Your Reference: SSD 8800
Our Reference: NCA/8/2017
Contact: Myfanwy McNally
Telephone: 9806 5447

6 November 2017

Re: Request for SEARs – Parramatta Leagues Club Hotel at 1 Eels Place, Parramatta (SSD 8800)

SHADOW ANALYSIS - PLAN DIAGRAMS

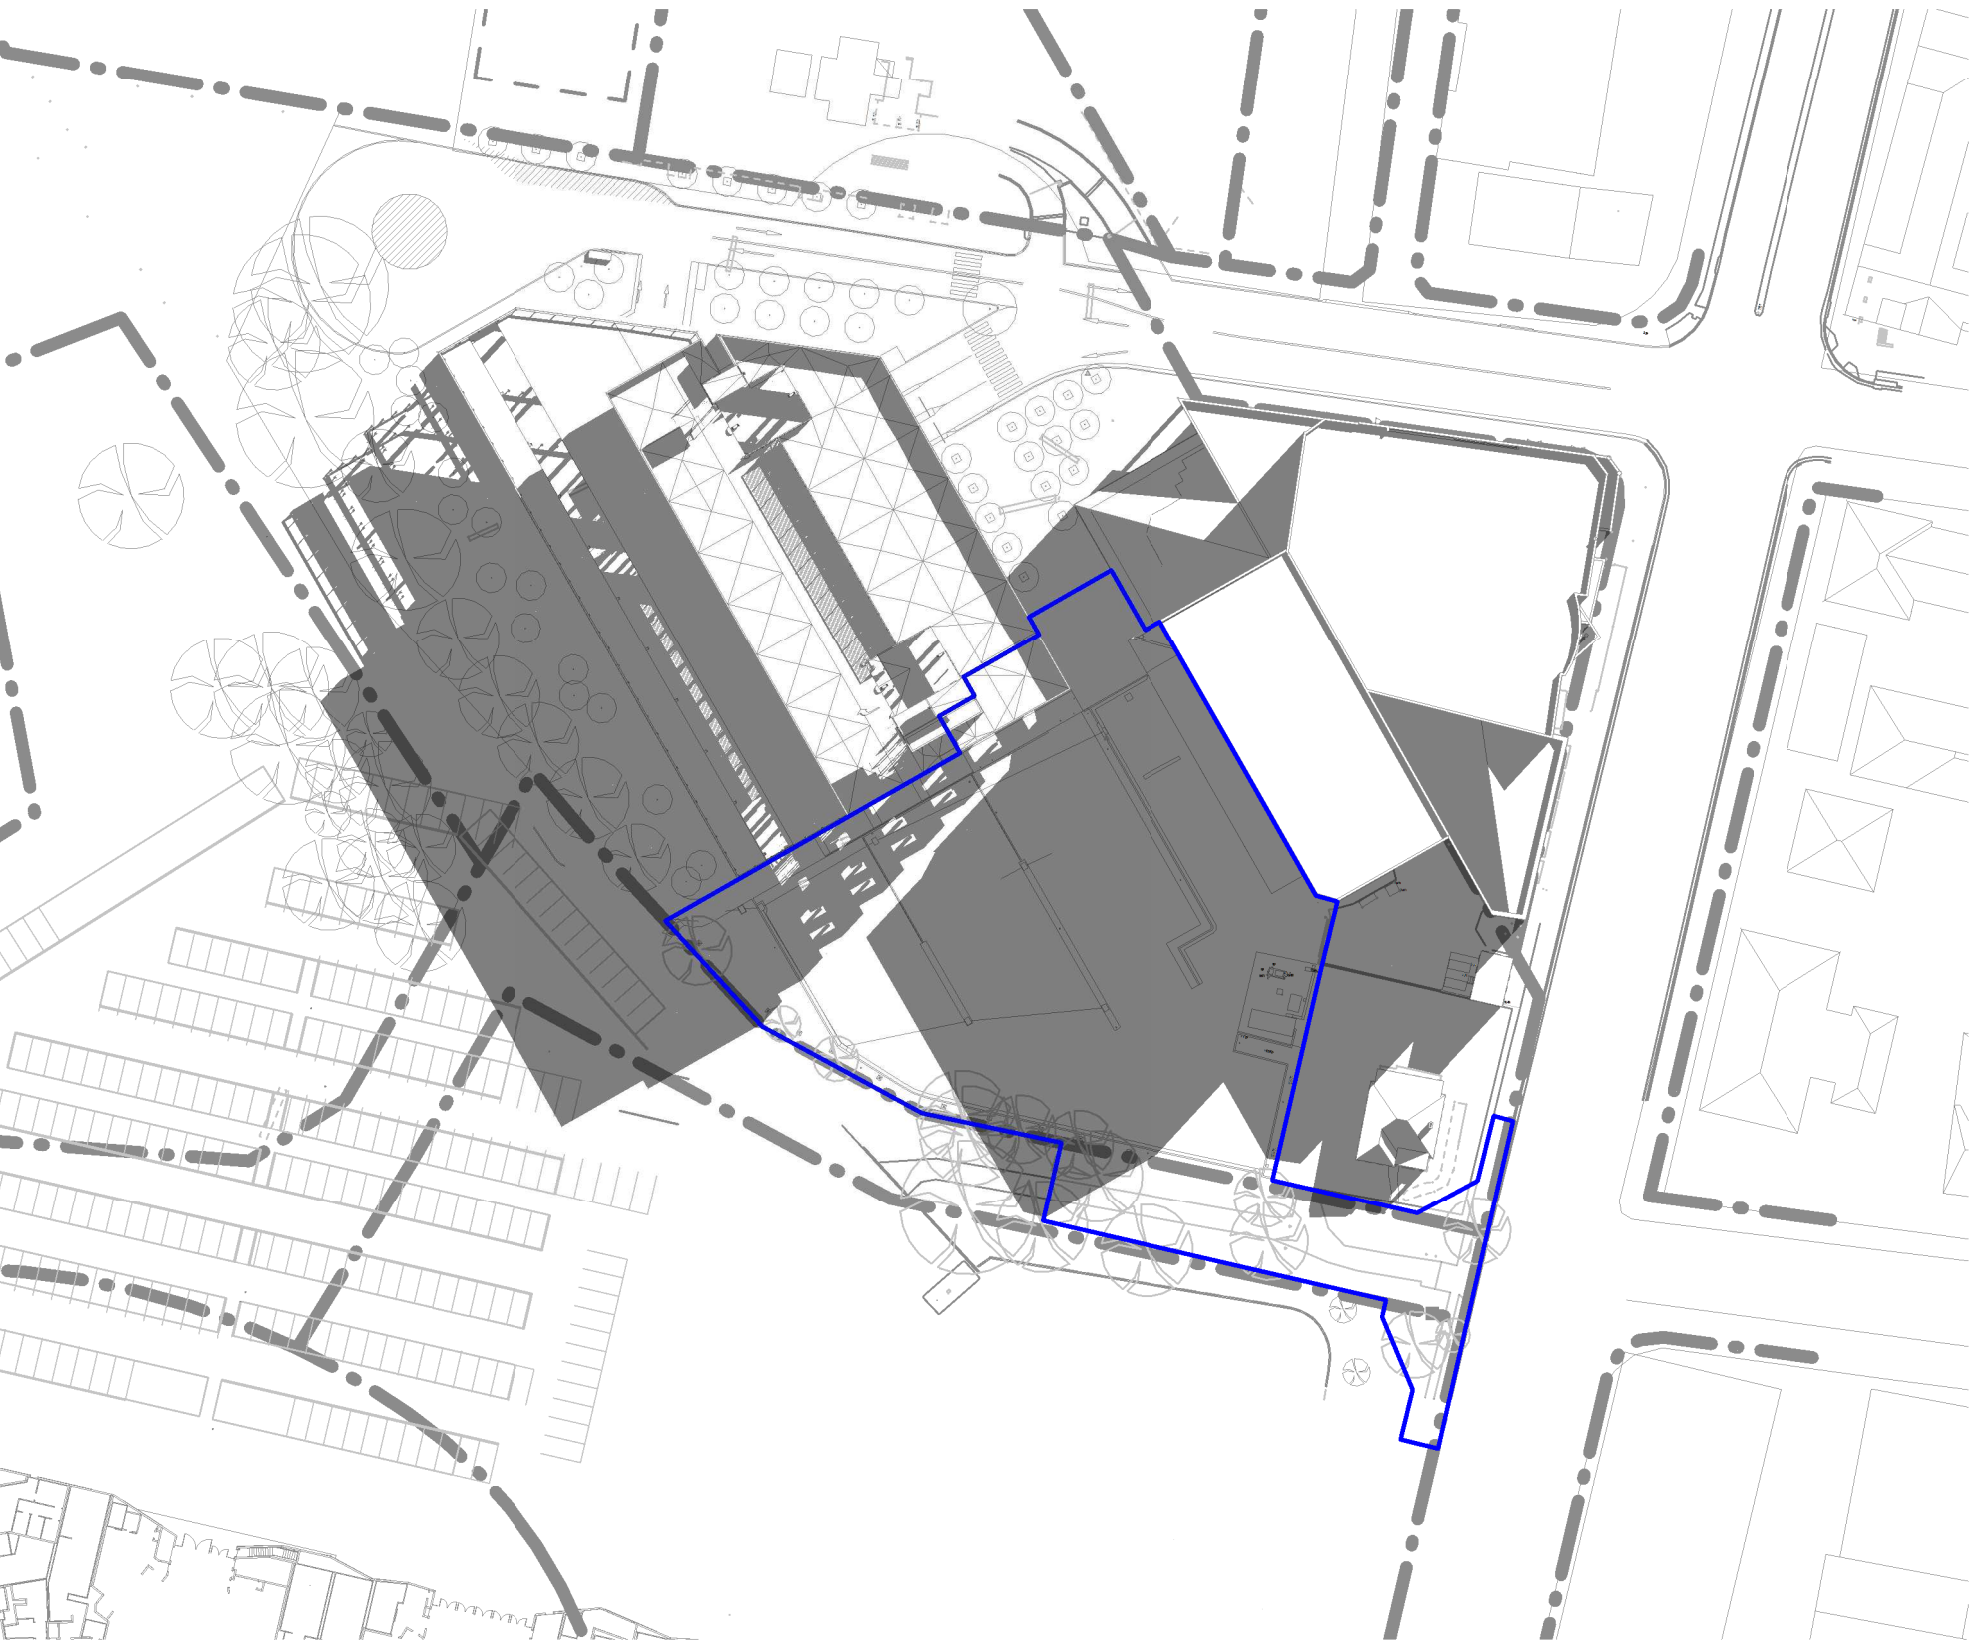
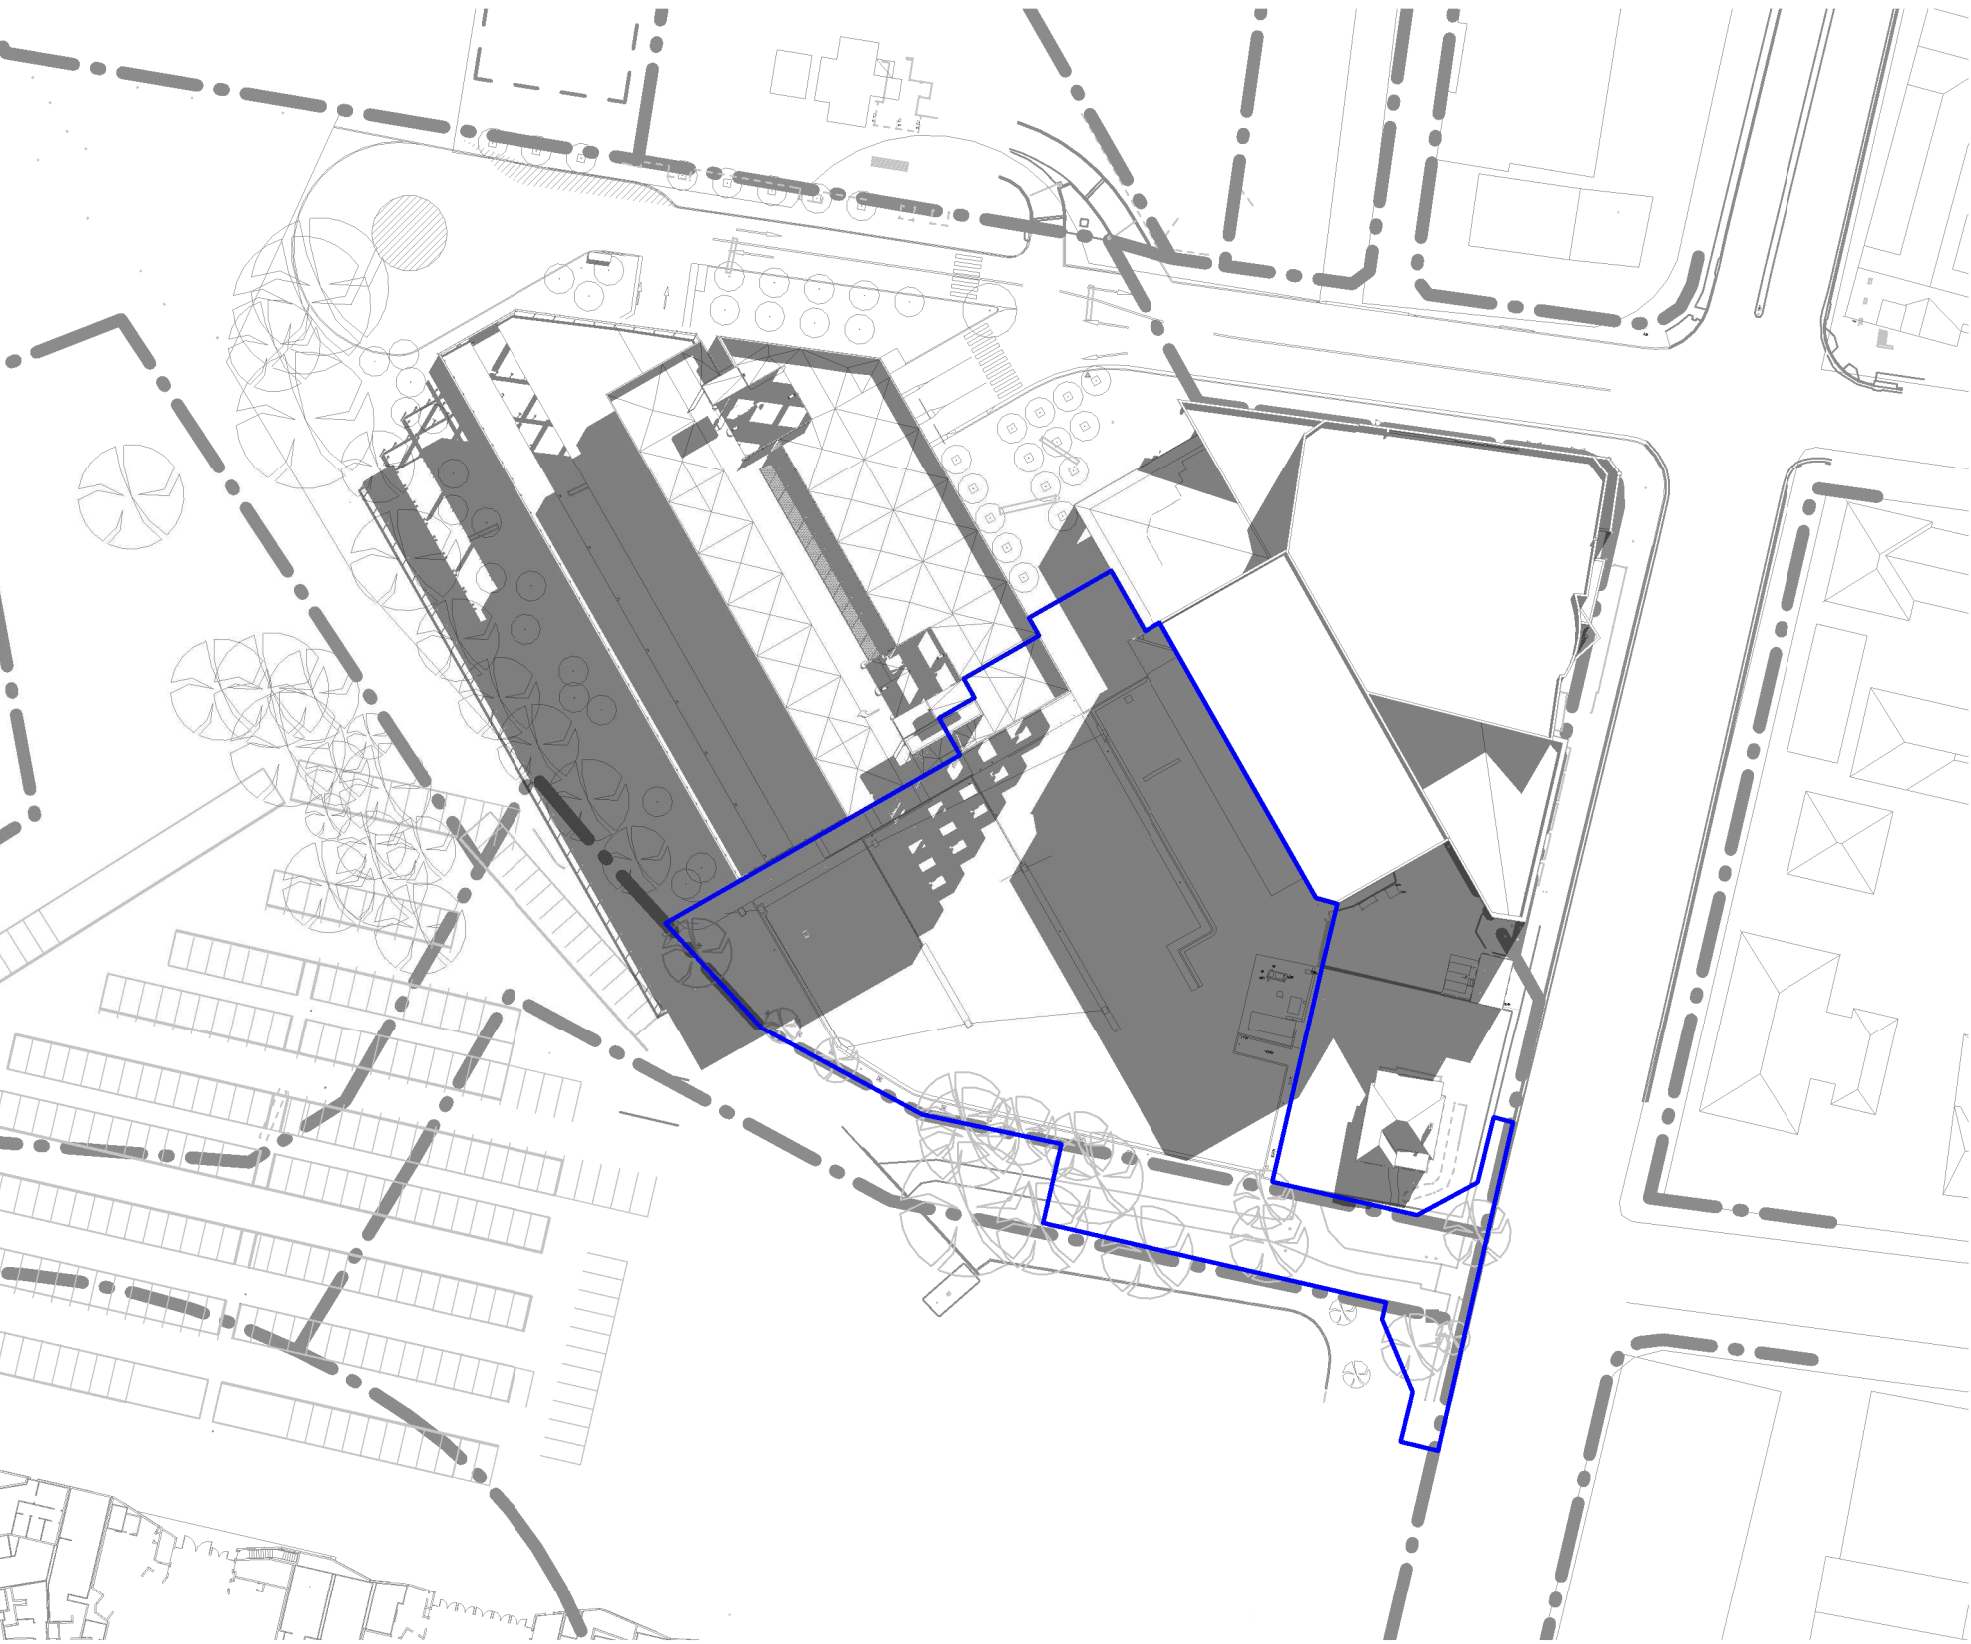
Hourly overshadowing plans should be included in the application for summer solstice, winter solstice and equinox. Diagrams are to clearly show the shadow impacts of the proposal on the surrounding sites and the public domain. Of particular note are the future Infrastructure NSW development and Parramatta Park located to the south of the site.
